PRELIMINARY DRAINAGE REPORT FOR THE VILLAS AT CLAREMONT RANCH

PUDSP-21-001

PRELIMINARY DRAINAGE REPORT
THE VILLAS AT CLAREMONT RANCH

## PRELIMINARY GRADING PLAN

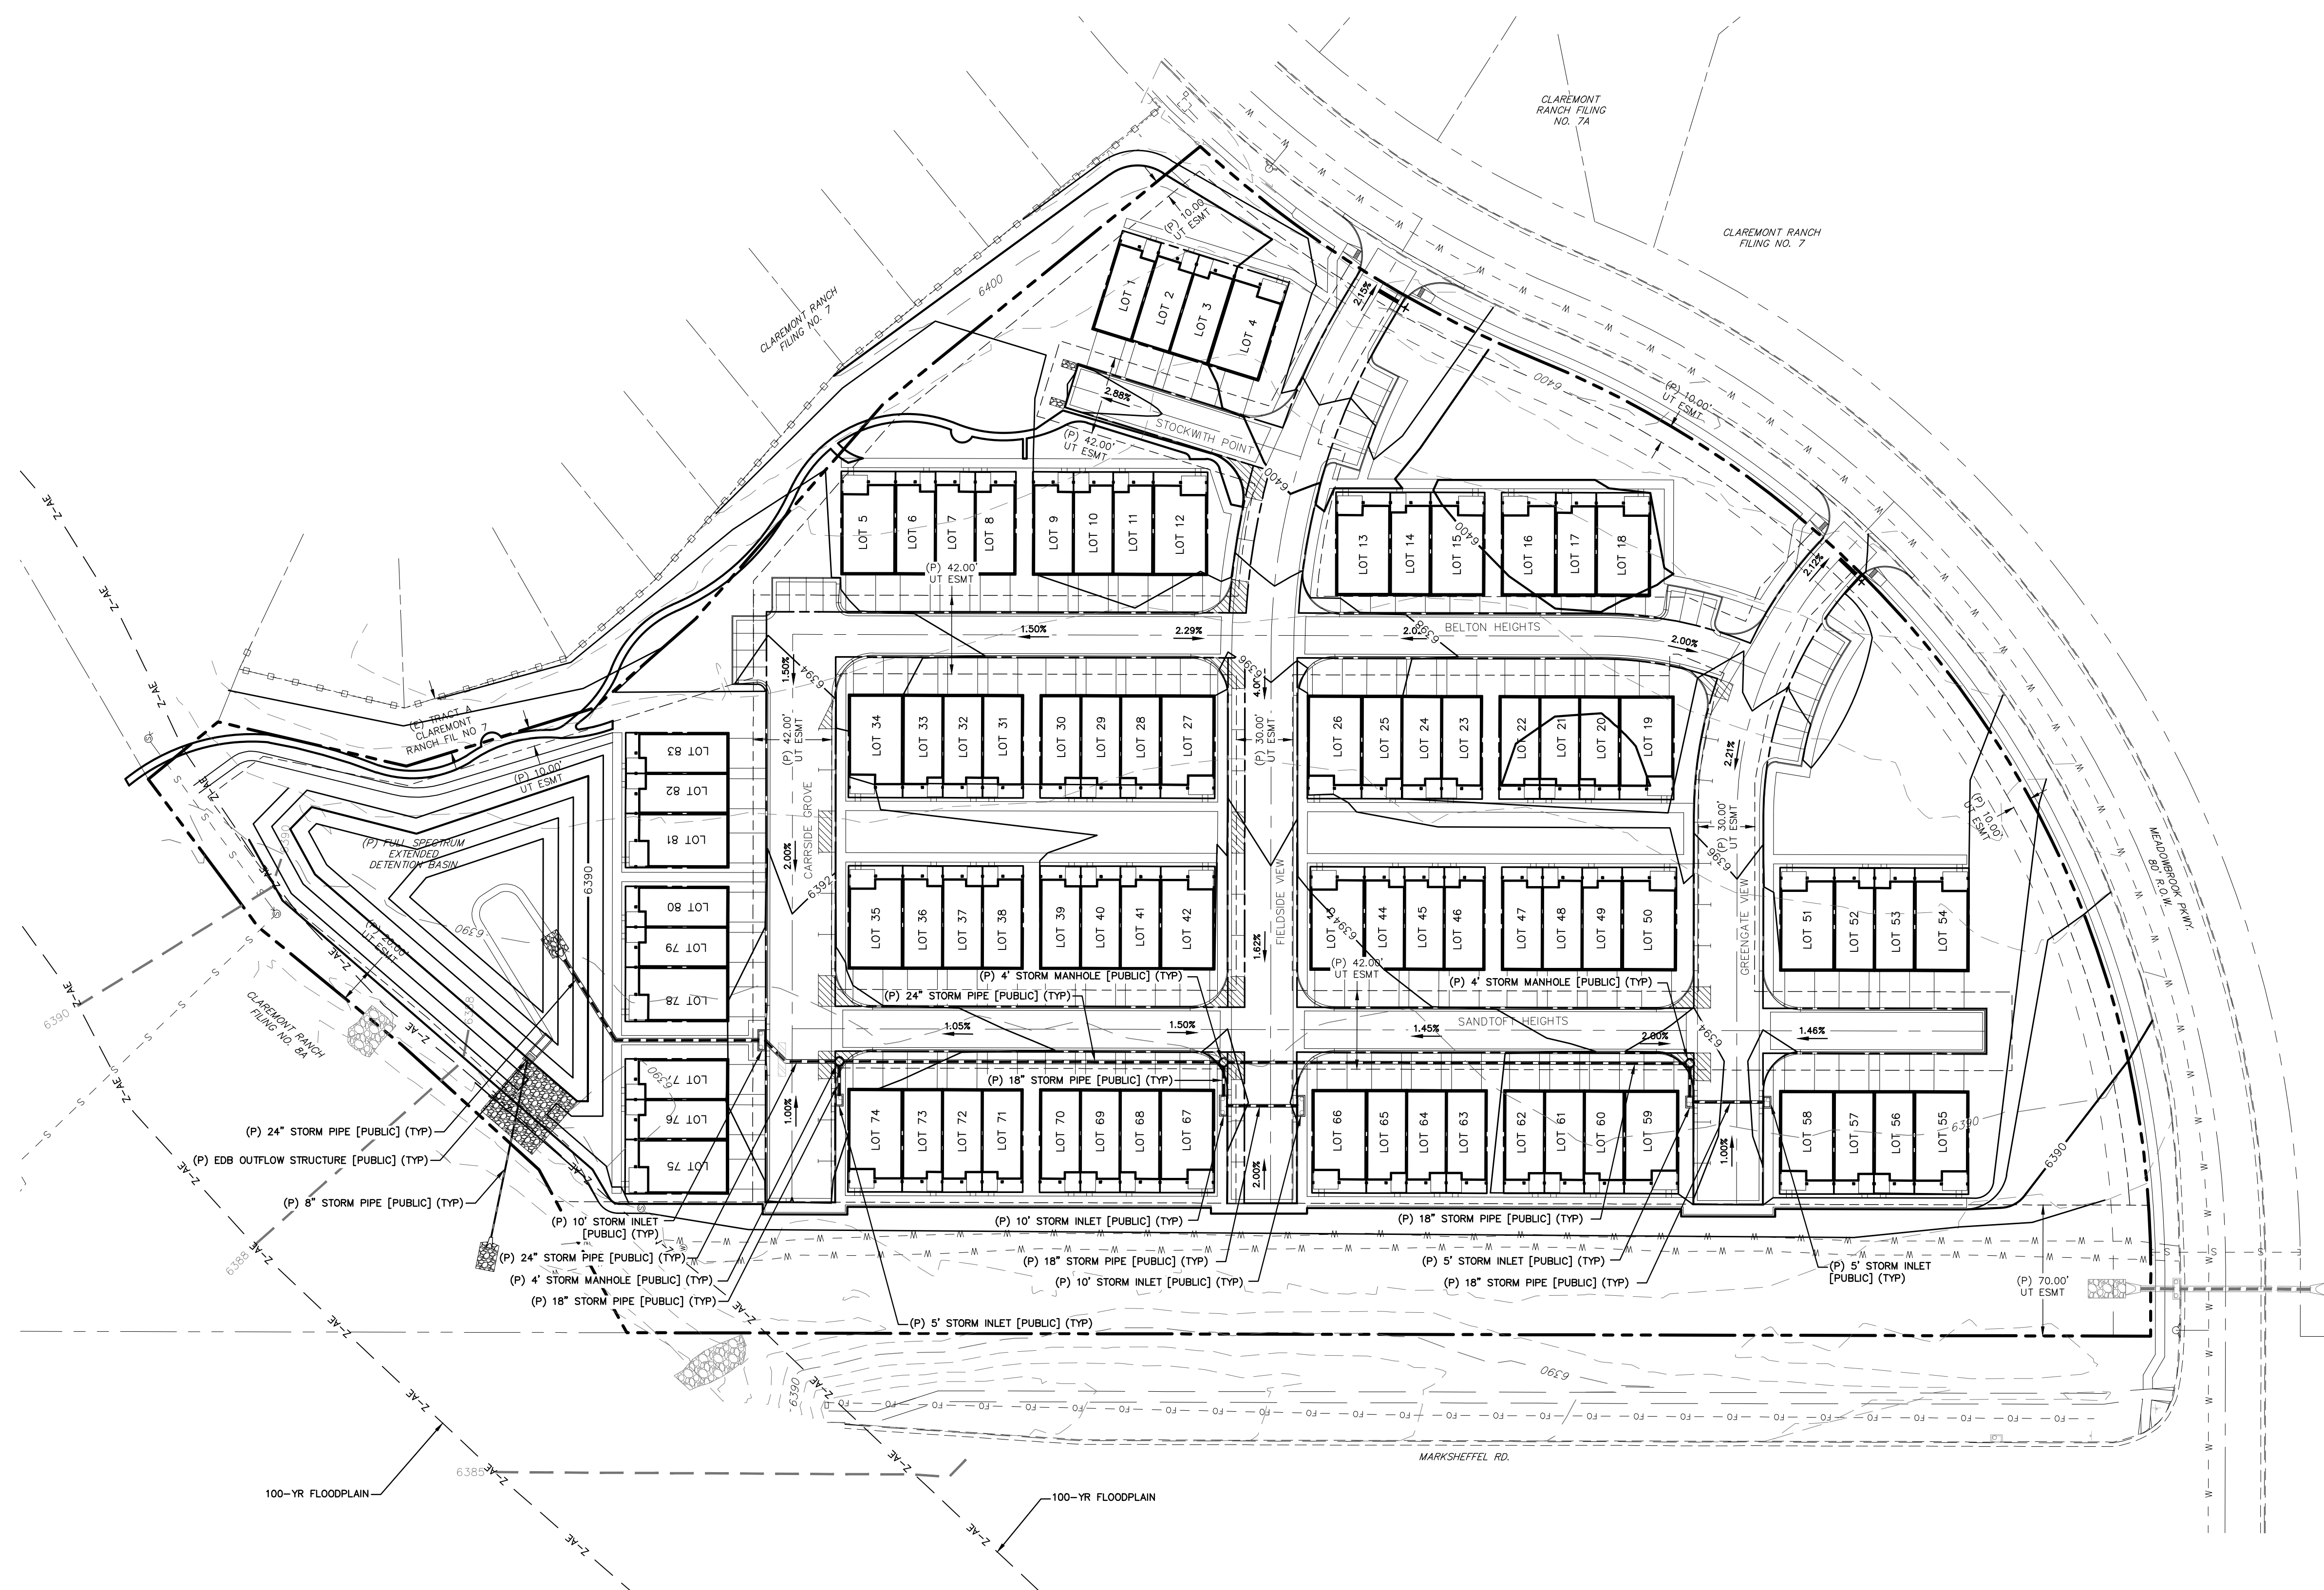
Include discussion on how flows will exit sump locations during early grading, prior to inlets being built.

Address the interim condition with the TSB after early grading. Provide SDI or MHFD calculation sheet showing drain times will work with TSB design. (A smaller TSB may be needed.)
